Technical Memorandum

Quality Information	
Project:	242-244 Beecroft Road, Epping (SSD 8784)
Project Number:	SCT_00045
Document Name:	Post Exhibition Responses to Traffic and Parking Addendum Memorandum
Date:	23 October 2019
Prepared:	Shawn Cen, Senior Consultant
Reviewed:	Jonathan Busch, Associate Director
Authorised:	Andy Yung, Associate Director

This memo is an addendum to the original report, modifying the traffic and parking content to respond to comments received during public exhibition under the category of Traffic, Transport and Parking as well as a number of other traffic related miscellaneous comments.

DRAWING TITLE	CONCEPT PROPOSAL P2
PLAN	
SCALE:	1:500 @A3
DRAWING NUMBER	3
REVISION	3

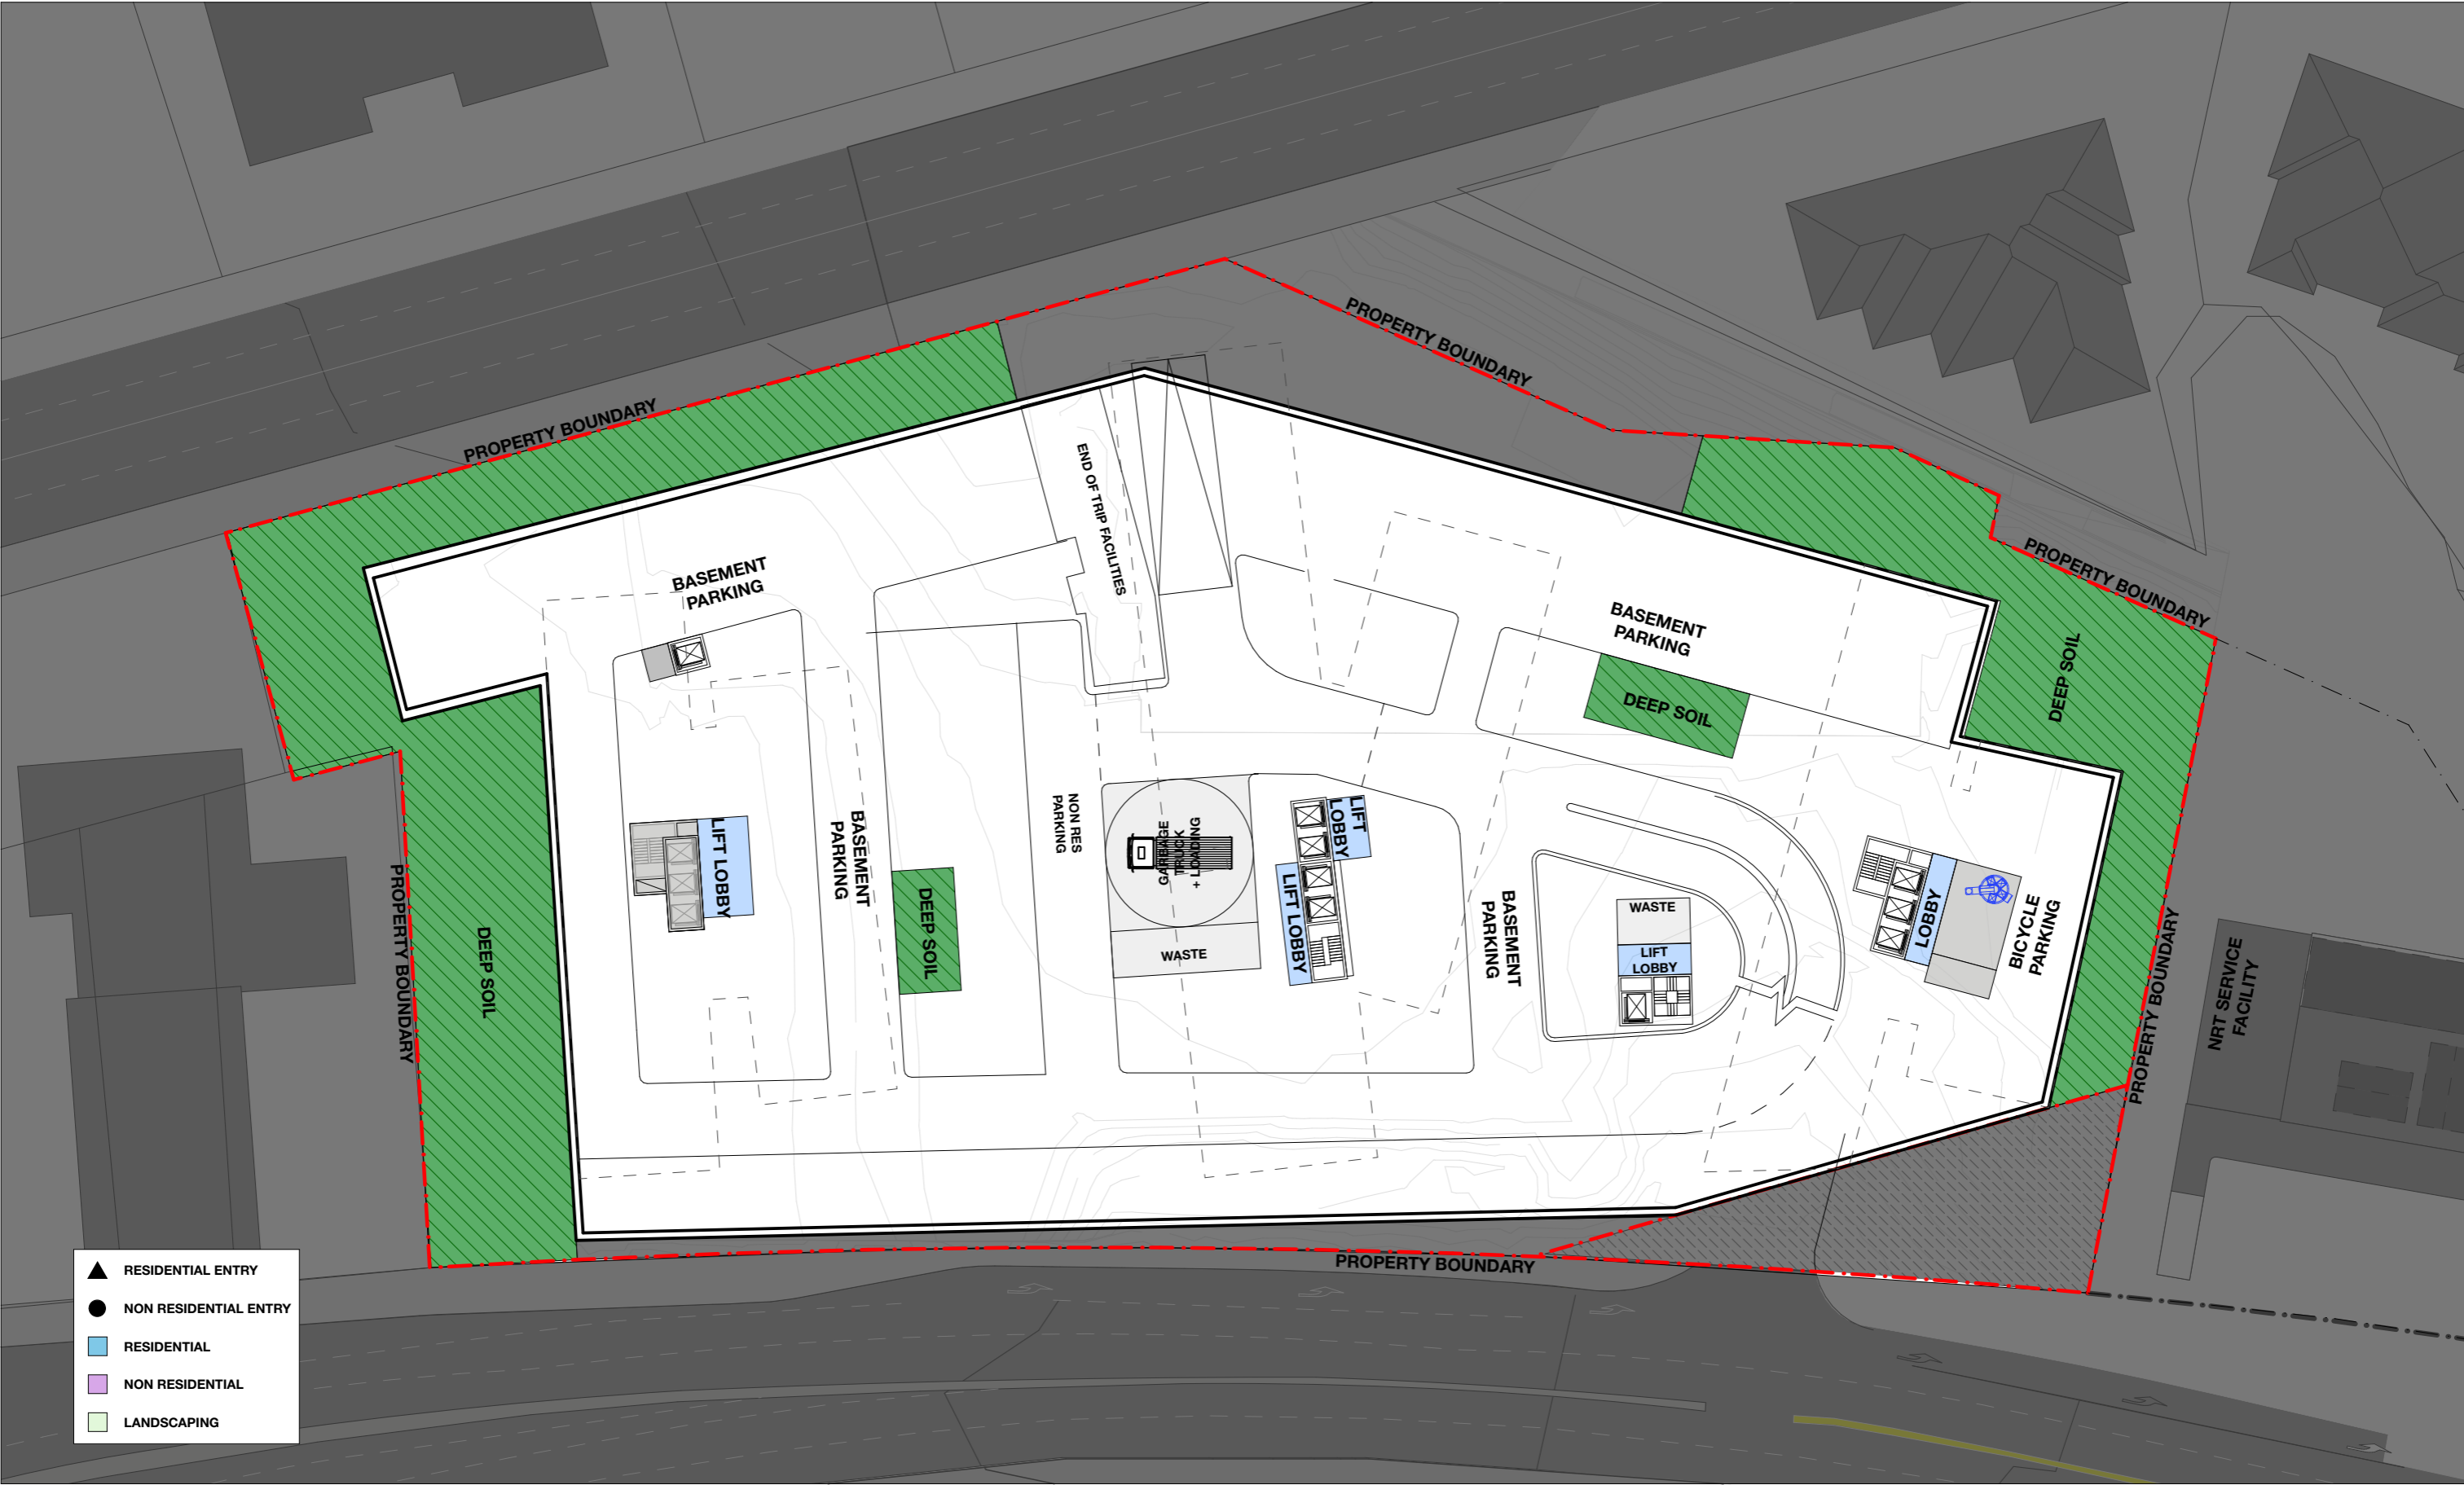
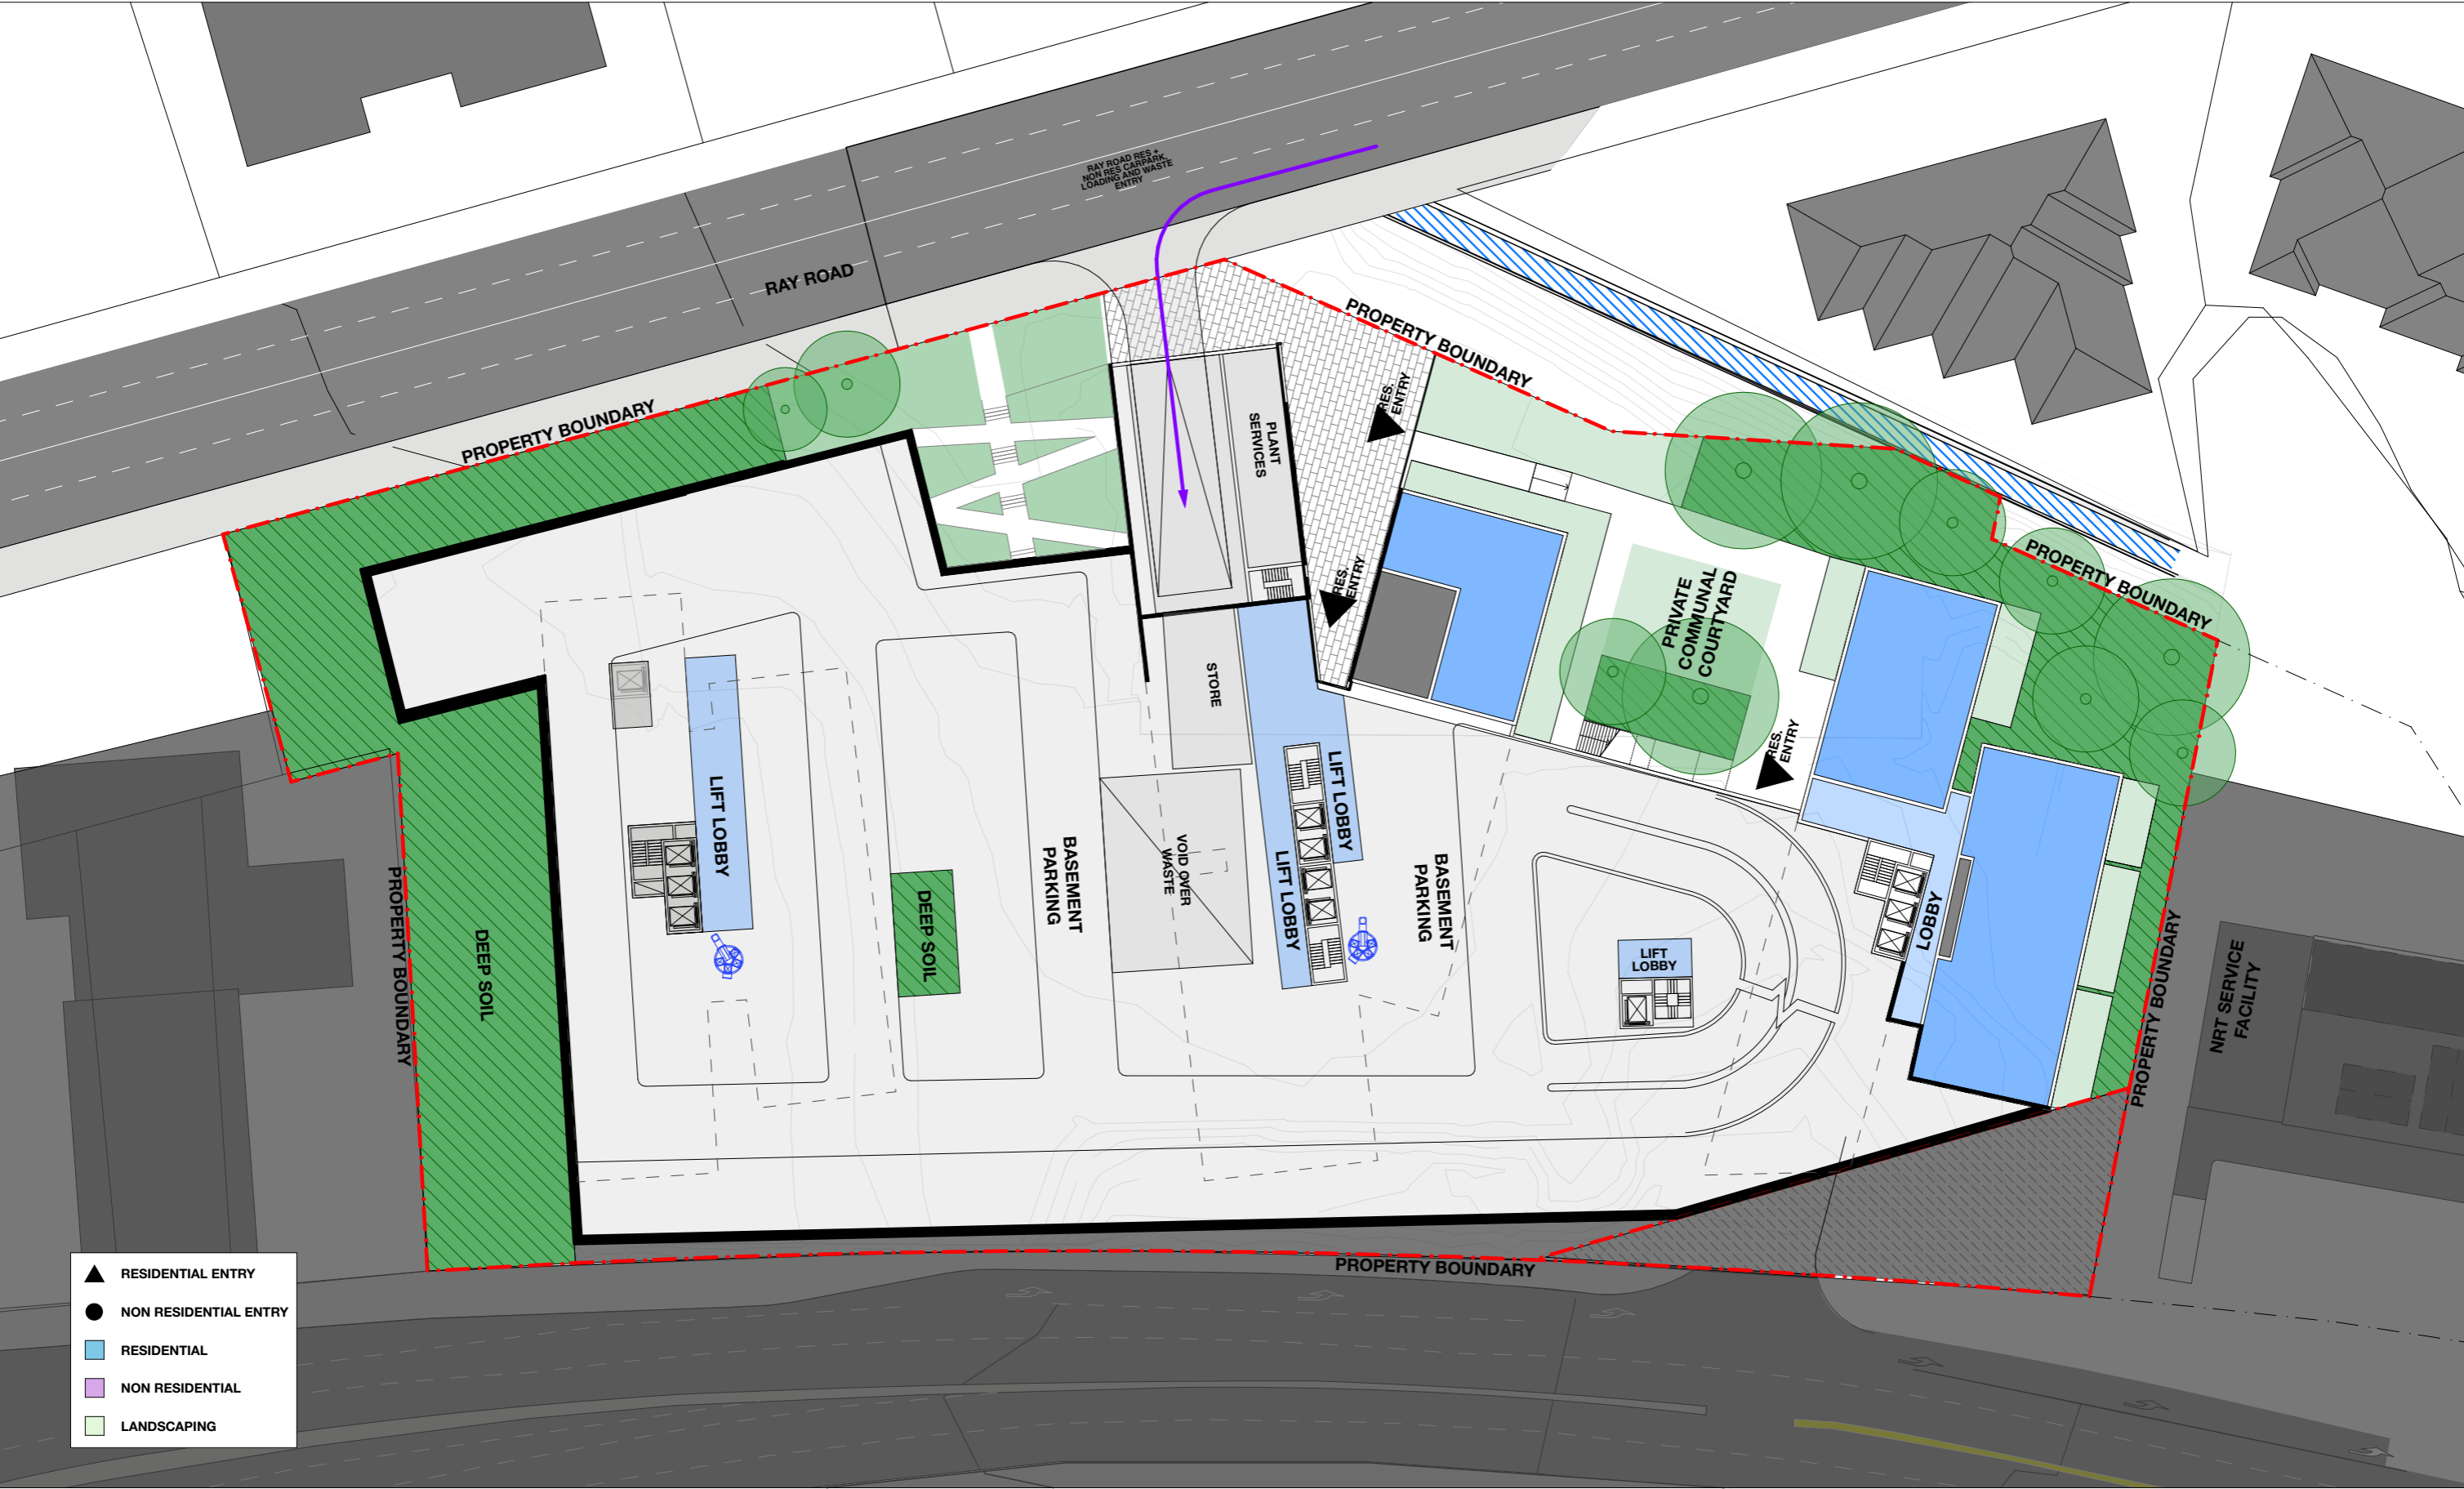
Reference	Post-exhibition comments	Responses
		<p>Figure 3 Proposed trip generation and distribution</p> <p>AM Peak – 82 trips (74 outbound & 8 inbound trips) PM Peak – 65 trips (7 outbound & 58 inbound trips)</p> <p>Note: No right turn to Ray Rd / Rawson St applies between 6-10am and 3-7pm (Buses excepted)</p> <p>Source: SCT Consulting, 2019</p>
<p>5. (i)(c)</p>	<p>Access to visitor and non-residential car spaces (with consideration of any traffic restrictions and reasonable way finding).</p>	<p>Vehicular accesses to the development are proposed at Ray Road and Beecroft Road. Both accesses are interconnected via the internal car park. The western access on Ray Road functions as a shared access for residential (visitors and non-visitors), non-residential and loading traffic. It directly ramps down to the basement level two as shown in Figure 4. The eastern access is a dedicated residential (visitors and residents) access at Beecroft Road as shown in Figure 5. It circulates down to the lower ground level and the two basement levels.</p> <p>Appropriate wayfinding signs are recommended internal to the car park to guide visitors to the dedicated visitor car parking spaces.</p>
